Botley West Solar Farm Project – Written Representations on behalf of Siemens Healthcare Limited

3. These representations concentrate on the key issue of the proposed cabling route and its impact on access to Siemens’ facility. Siemens’ position is otherwise reserved in regard to the content of the DCO application documents.

9. It is proposed as part of the Project to use land owned by Siemens to install cabling. The Order Limits identifies the requirement for an easement along Wharf Road which will run east from the junction with the B4044 along the length of the road and across the facility’s rear car park at the eastern end of Wharf Road, all of which are within Siemens’ ownership (Title No. ON129217). Part of Wharf Road is adopted by Oxfordshire County Council and the remainder is a private road. Siemens needs uninterrupted access over the entire road.

Title: Illustrative Masterplan
Figure 5.5
 Cable Corridor Plan Overview –
 Land between the Central and Southern Sites east
 and south of Eynsham around the Swinford Bridge

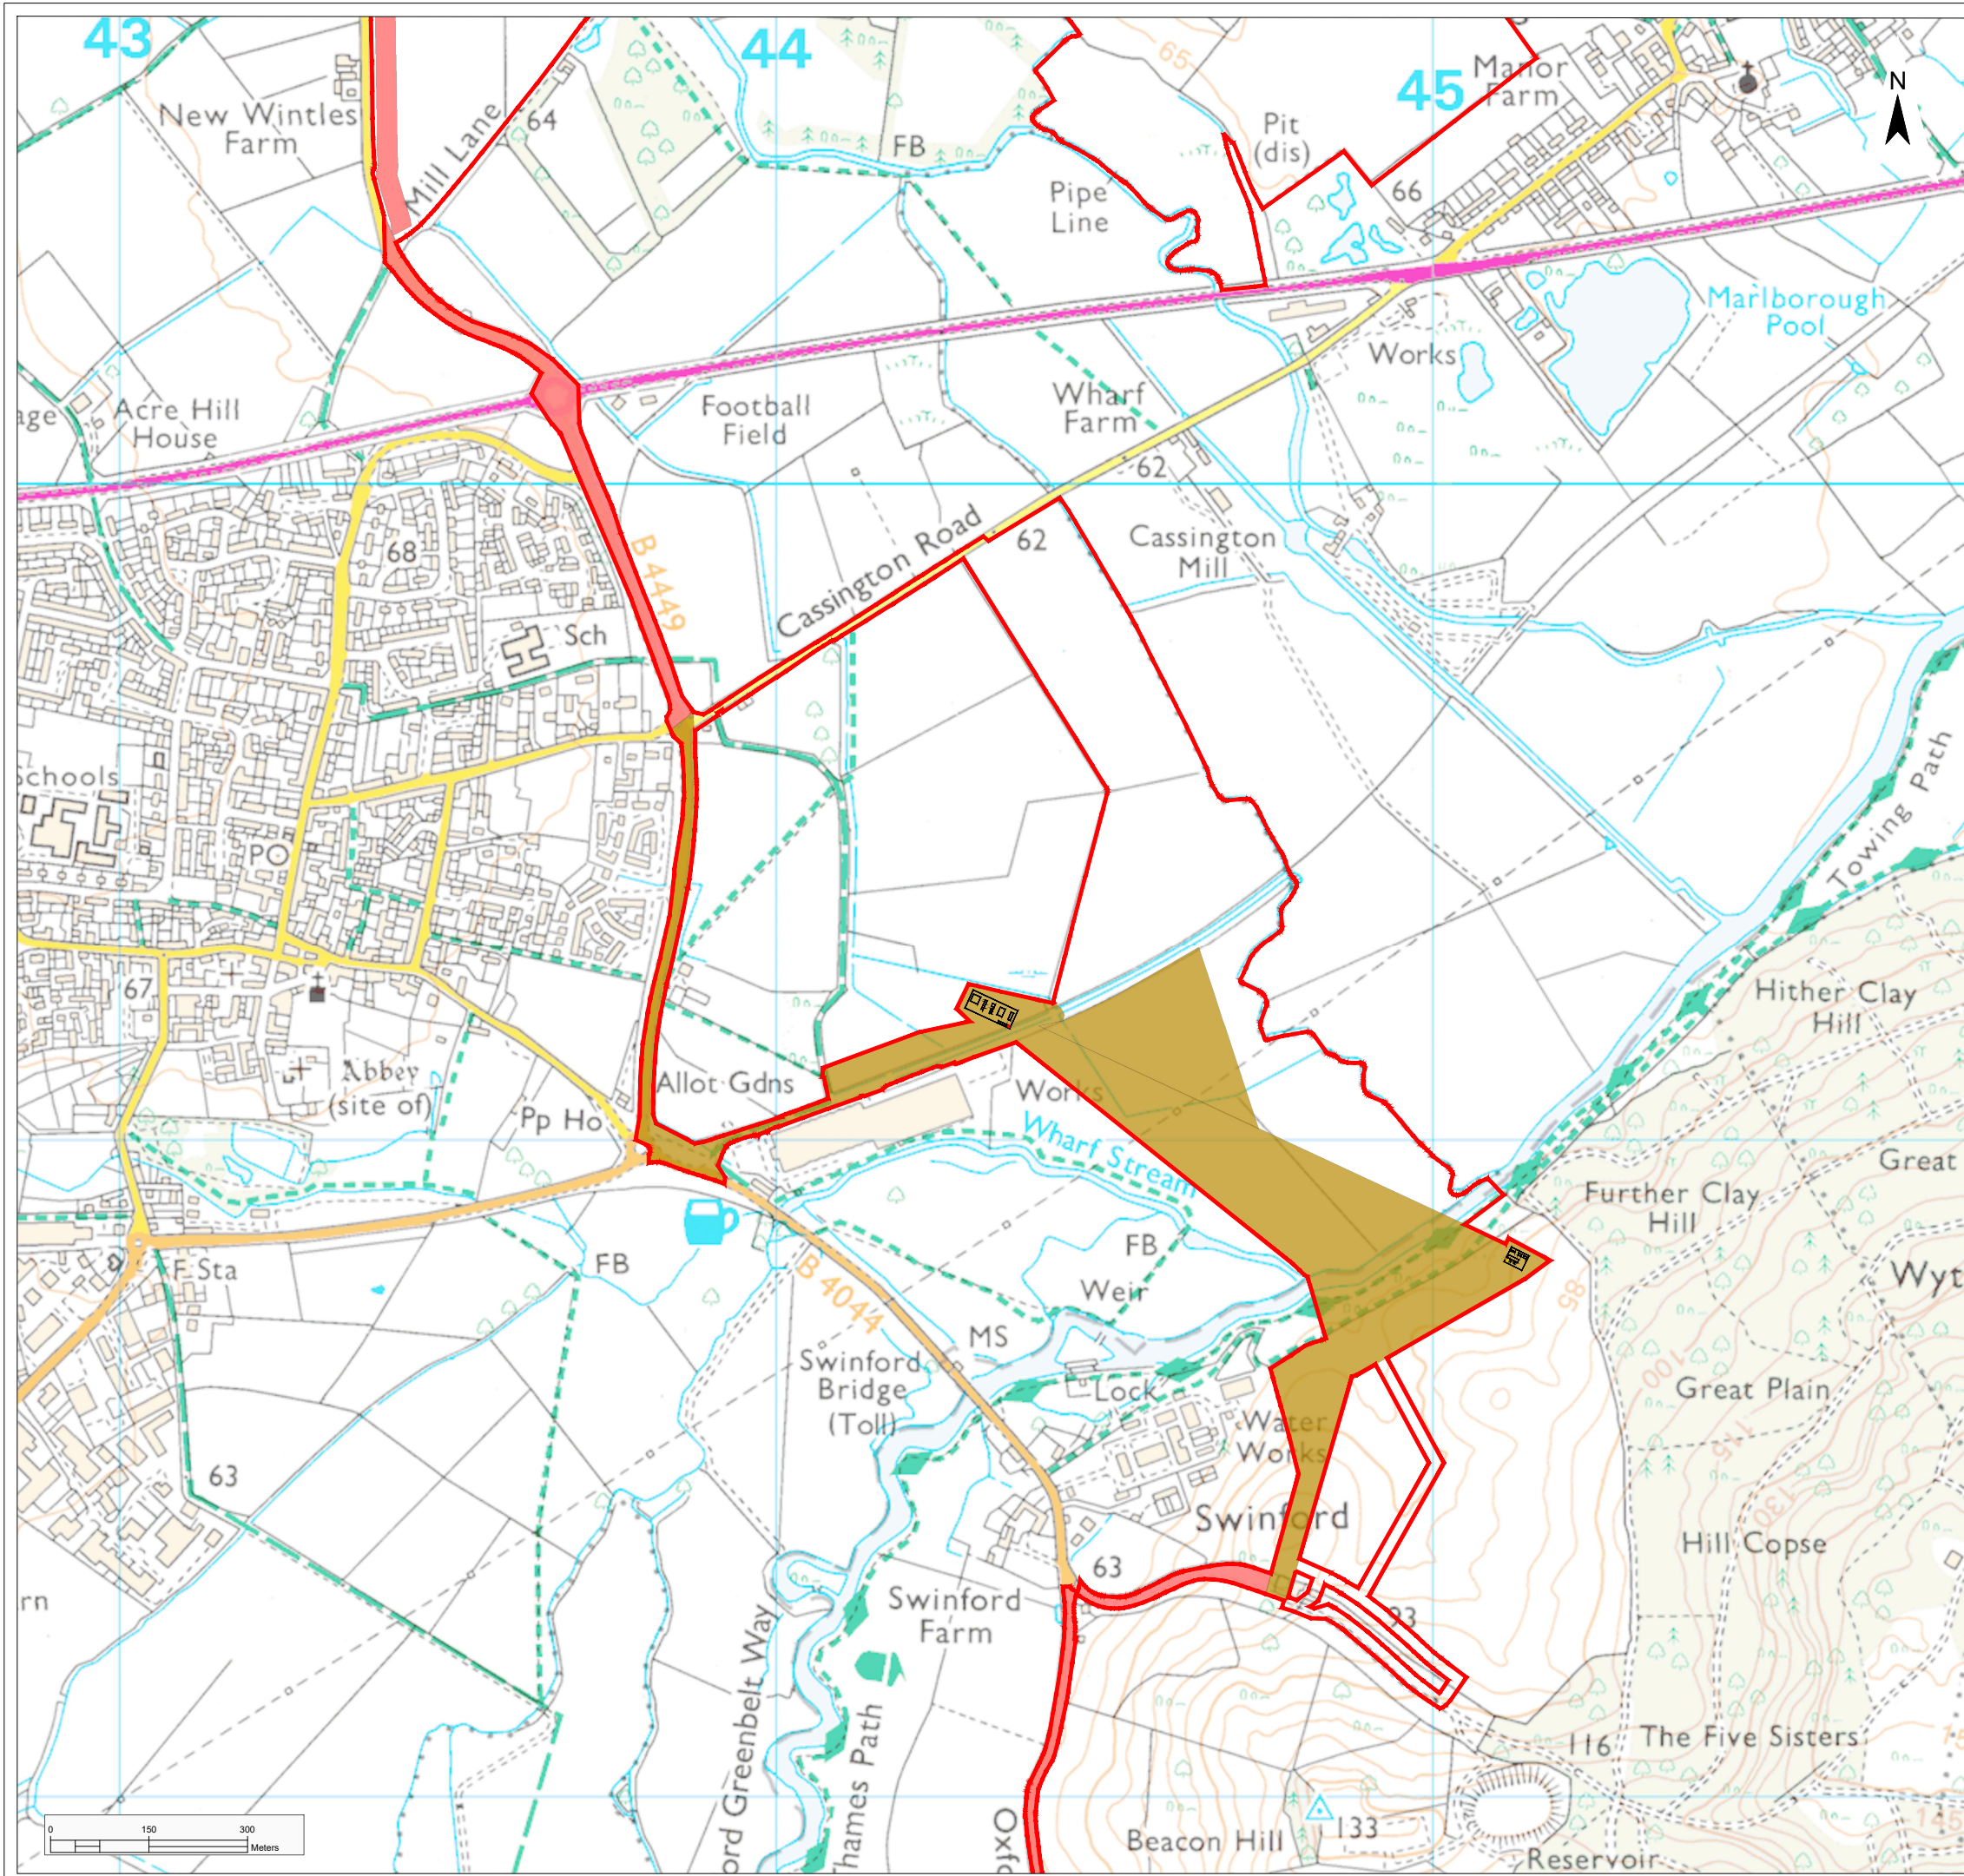
10. PVDP and their advisors have since confirmed that the cabling route that passes along Wharf Road through Siemens’ security gates and into the rear car park is to be removed, leaving the preferred route on Siemens’ Land which is along Wharf Road, entering adjoining land shortly before the security gates. Whilst this change is welcomed by Siemens, it does not resolve the central issue: interference with Siemens’ continuous access to its facility via Wharf Road. Siemens’ major concern over disruption to operations remains, with the consequent risk to the supply of MRI scanners.

11. The Order Limits identifies two, alternative cabling route options:

- a. Siemens’ Land; or
- b. Cassington Road.

12. The proposals do not provide adequate criteria for the choice between the two options, including the weight that will be given to the risk of disruption to Siemens’ facility and the resultant cost. Siemens’ advisors, JLL, requested this information on a call on 5th September 2024 between JLL, Ardent and PVDP. On the call it was agreed that PVDP would provide an analysis of the pros and cons of each option.

17. In our view, the cable routes are an integral part of assessing the impact of the project as a whole. It is late in the day, the Examination having begun, for the Applicant not to have provided the final design of its routes. We request that the Applicant provides the final design as soon as possible.
